Our Ref: EN020002

Date: 23 May 2023

Application by National Grid Electricity Transmission for an Order Granting Development Consent for the Bramford to Twinstead Reinforcement

Advice following issue of decision to accept the application for examination

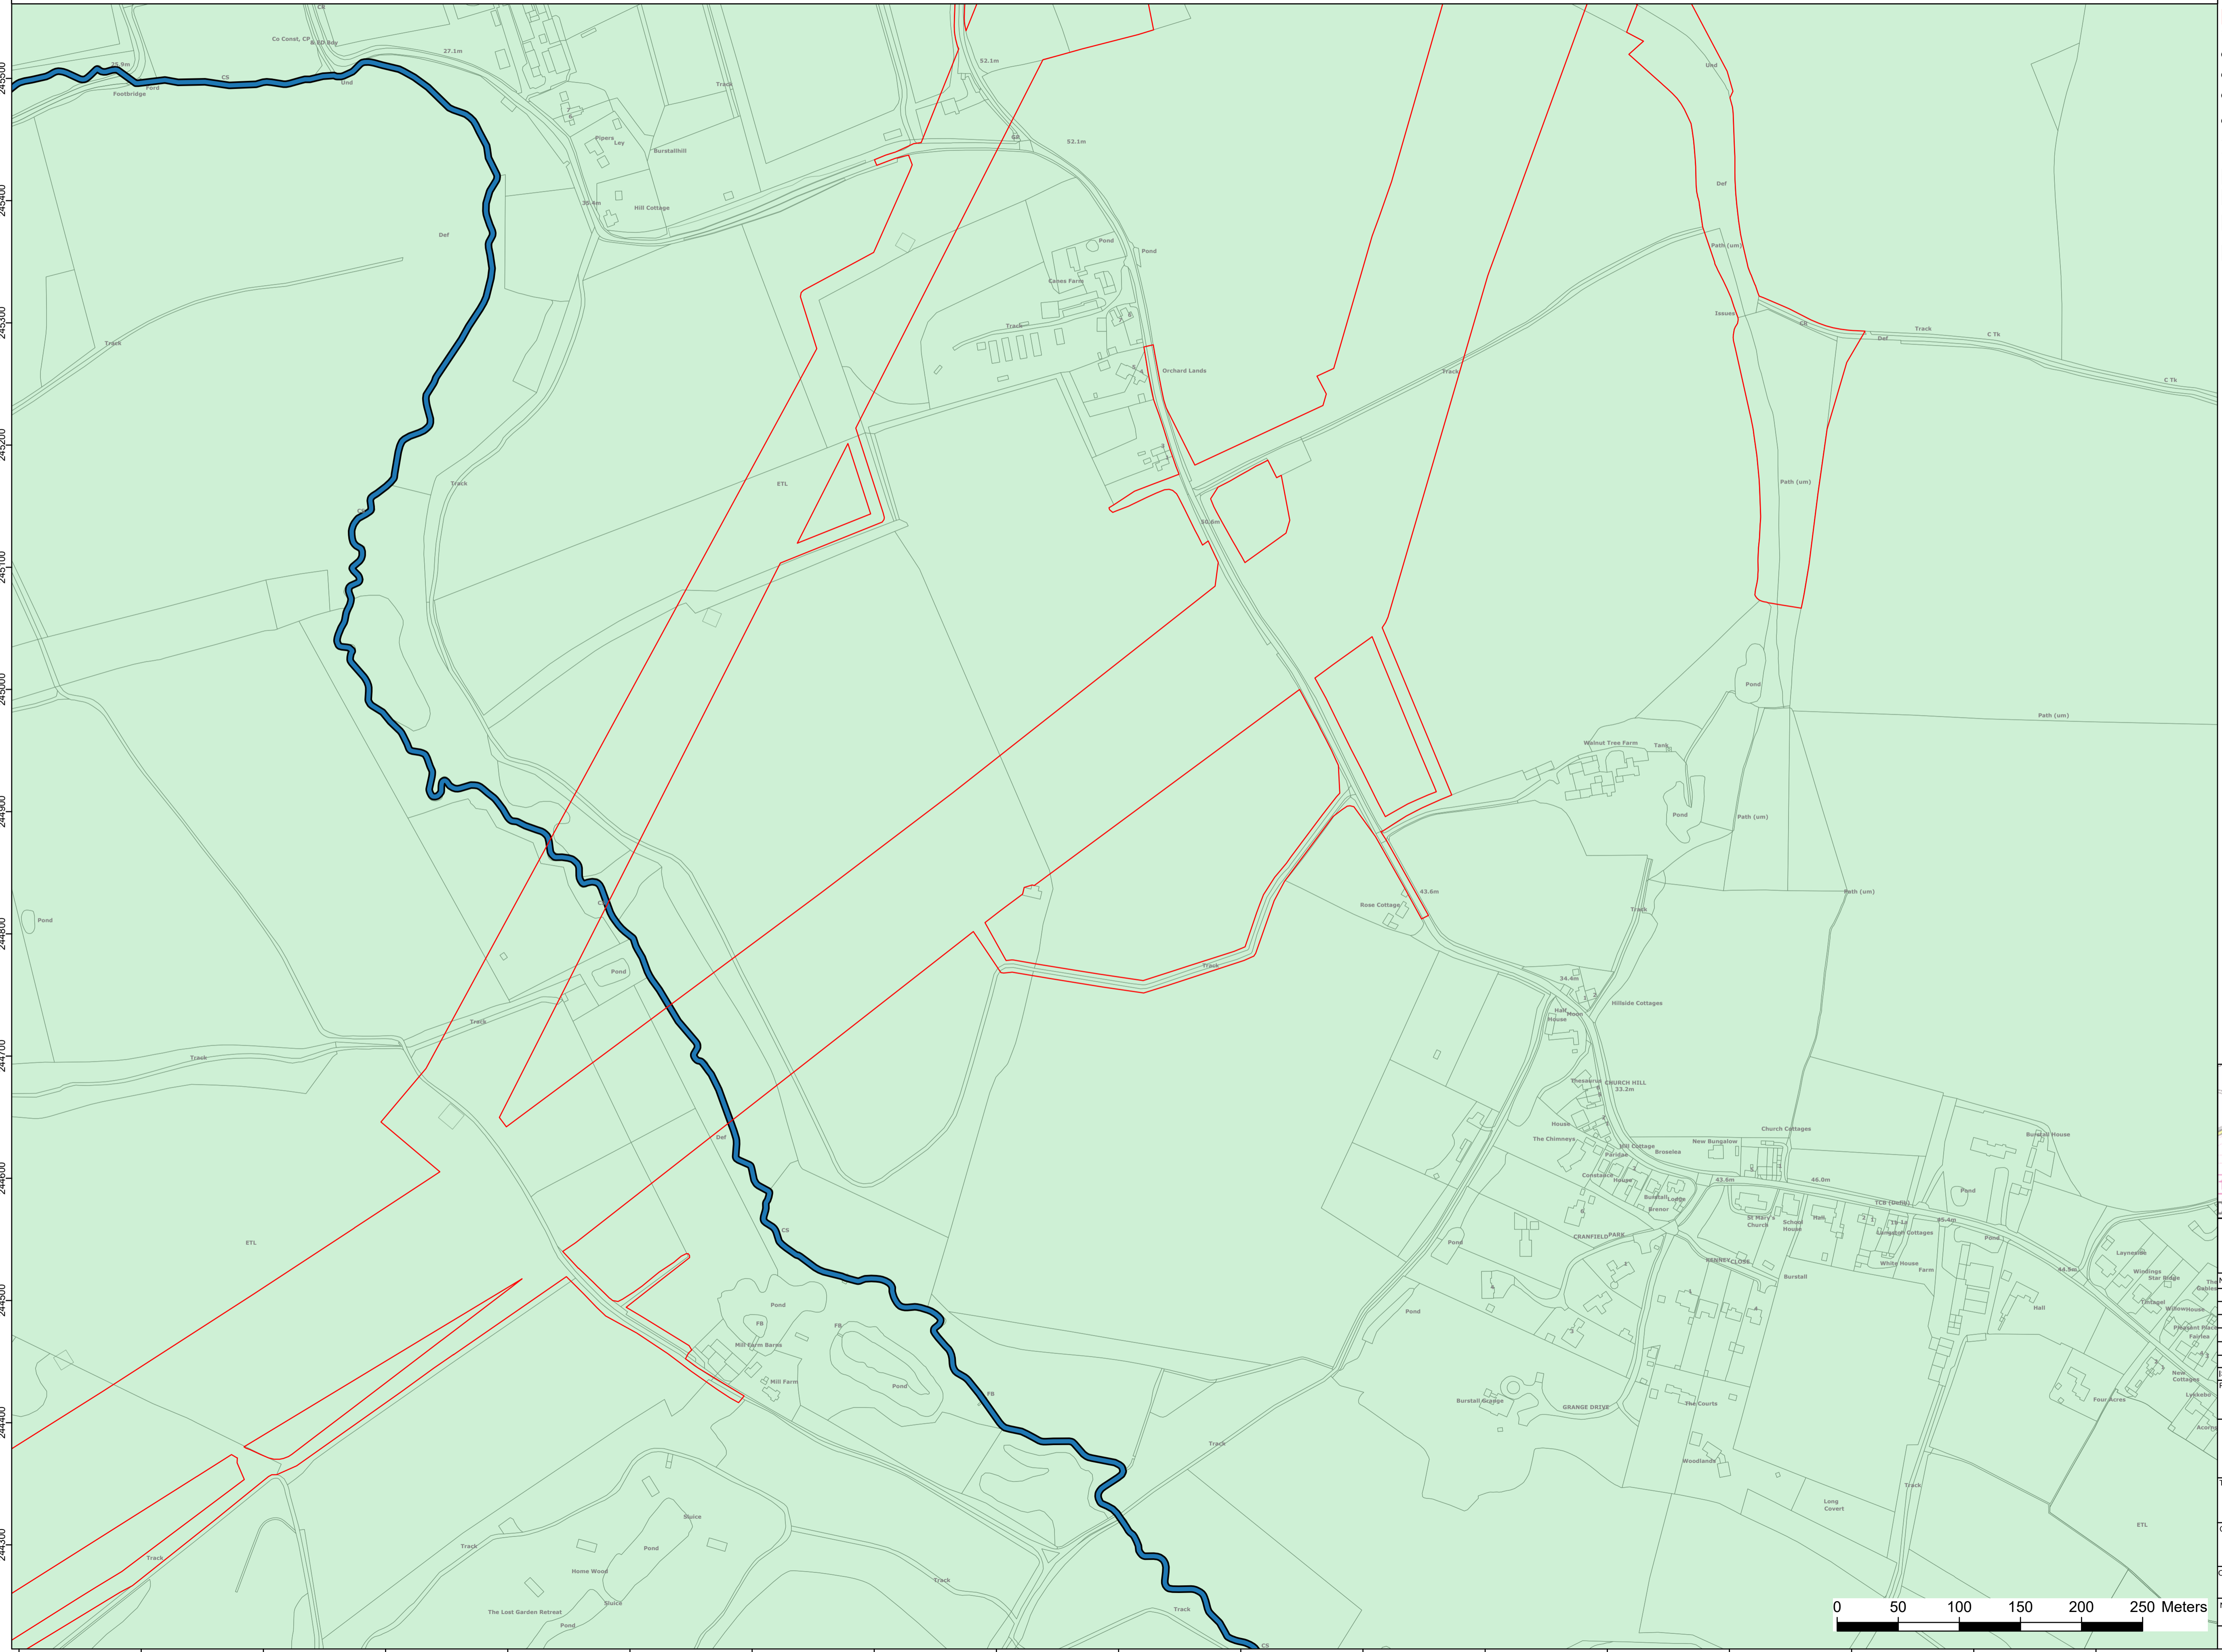
River Brett and River Box are identified as WFD water bodies. They are listed in the key of **Doc 2.8.4**, which comprises plans showing the location of WFD water bodies that could be affected by the Proposed Development but are not shown on Sheets 10 and 14 of the plans respectively. The locations of the River Brett and River Box are shown on Figure 1 of the WFD Assessment (**Doc 5.6**).
